Re: Letter of Intent – 5930 Paonia Ct – Minor Development Plan

Please accept this Letter of Intent as required for the Minor Development Plan.

LANDSCAPE PLAN EXISTING/PROPOSED

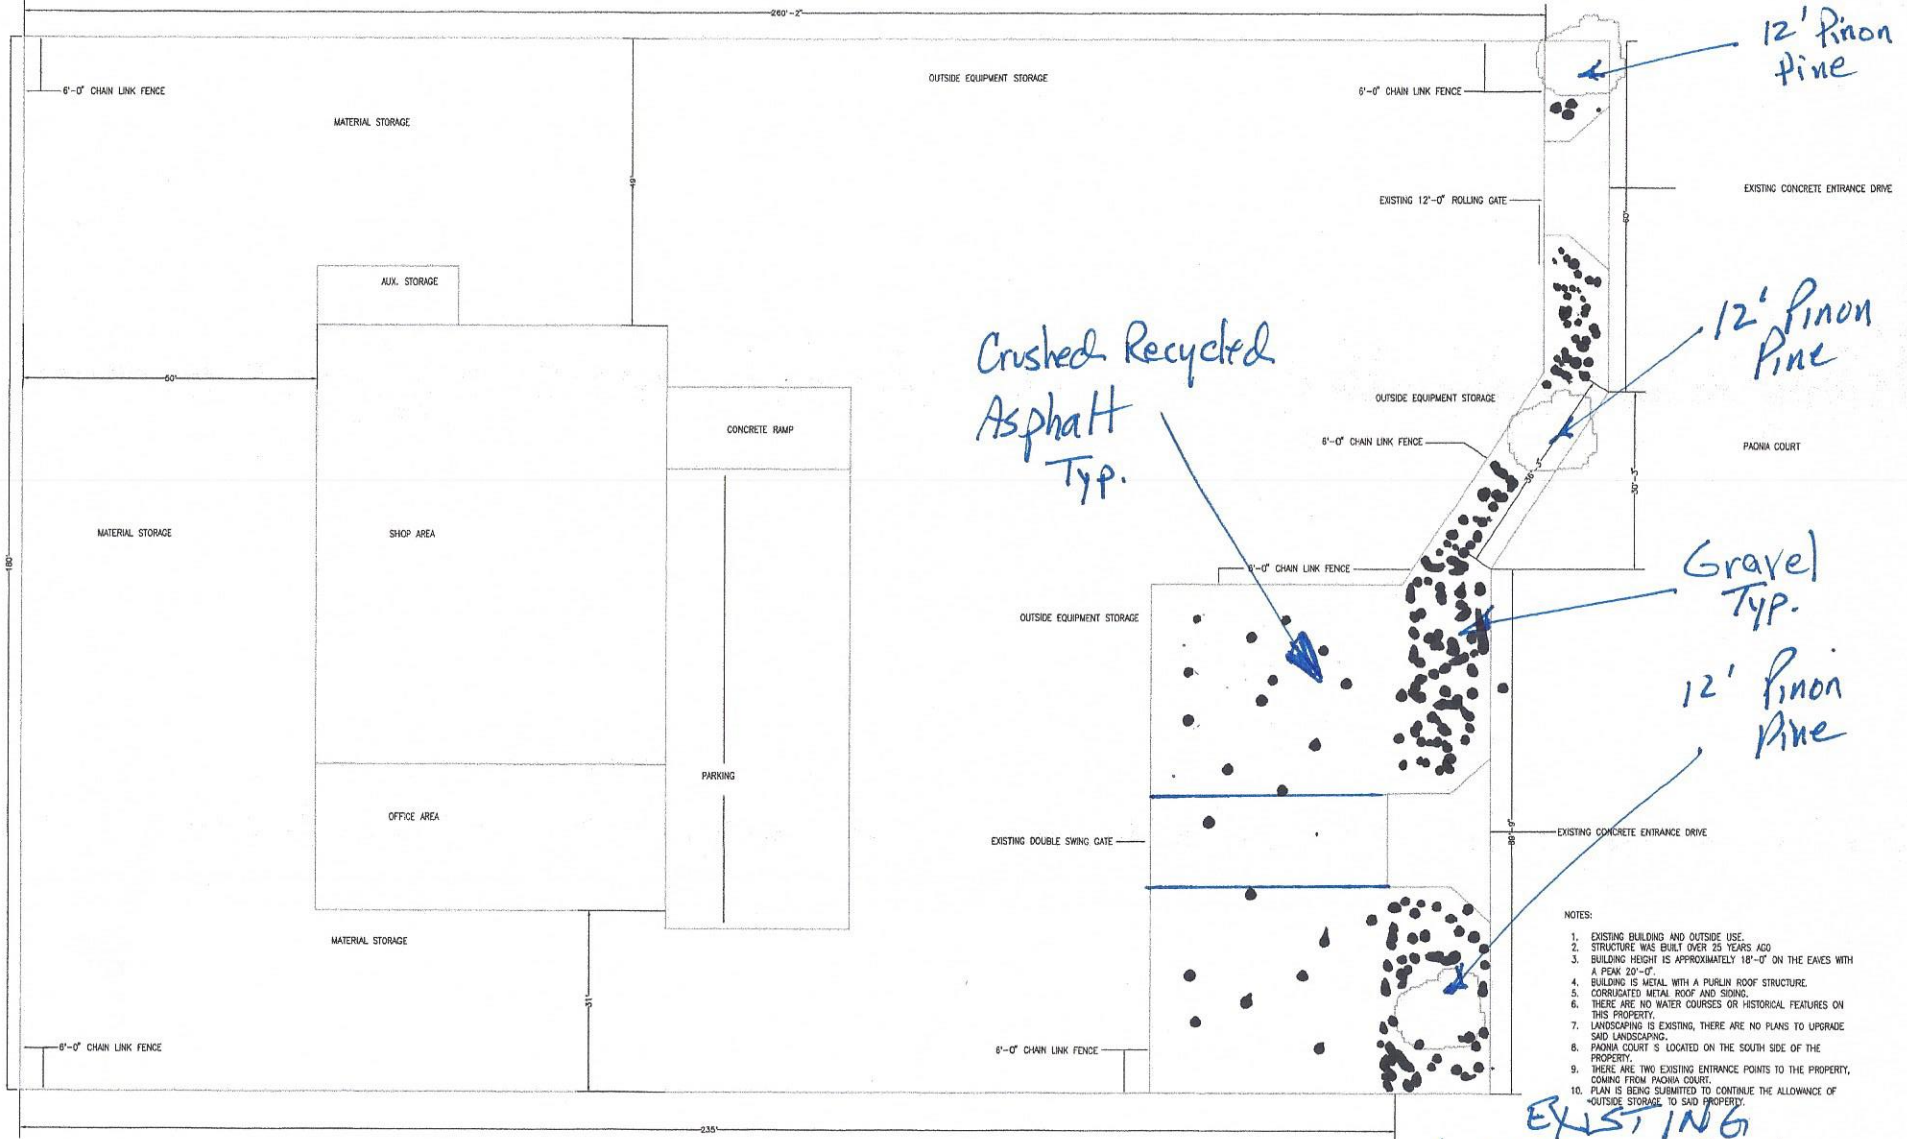
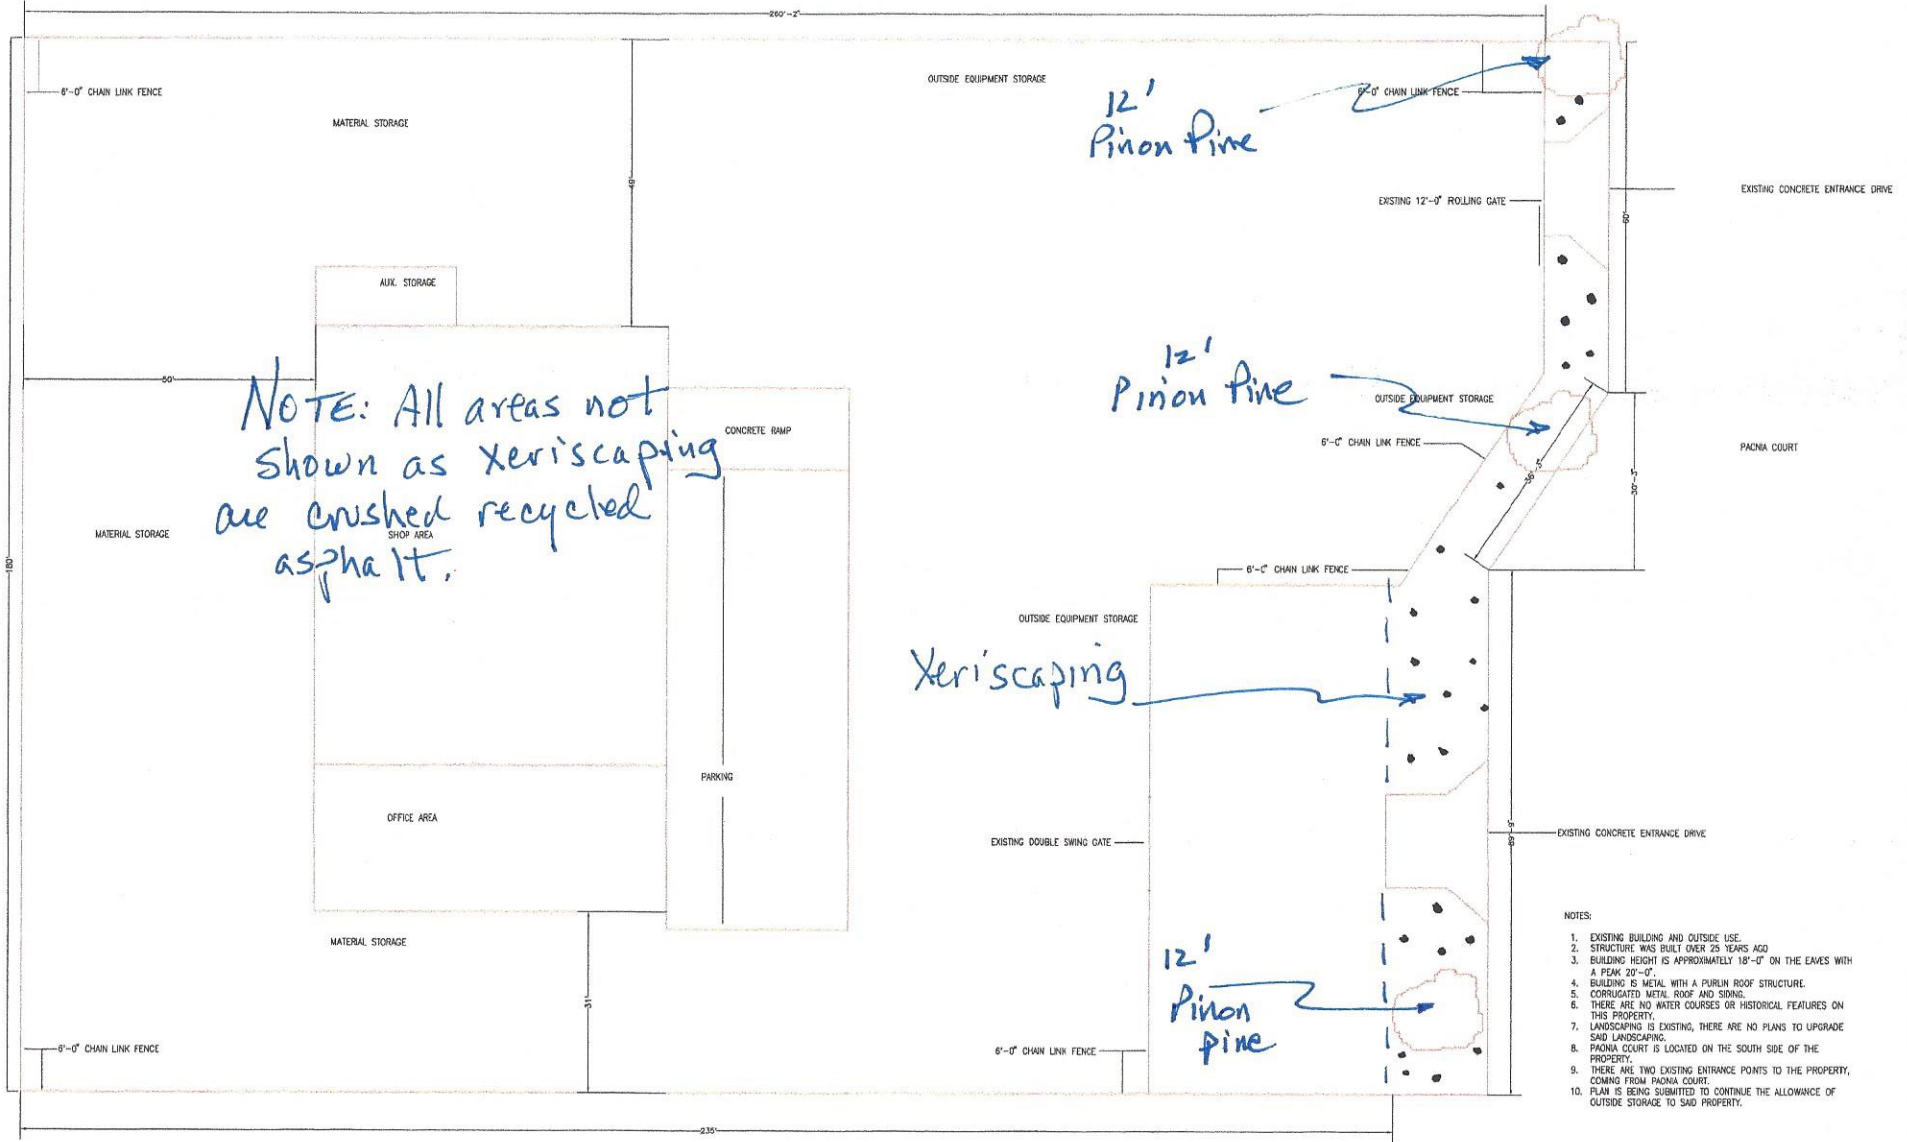
This currently does not meet the landscaping requirements of the Land Development Code, If you are requesting an alternative landscaping request you should include a paragraph in this letter asking for an alternative landscaping request and justifying why you need the alternative.
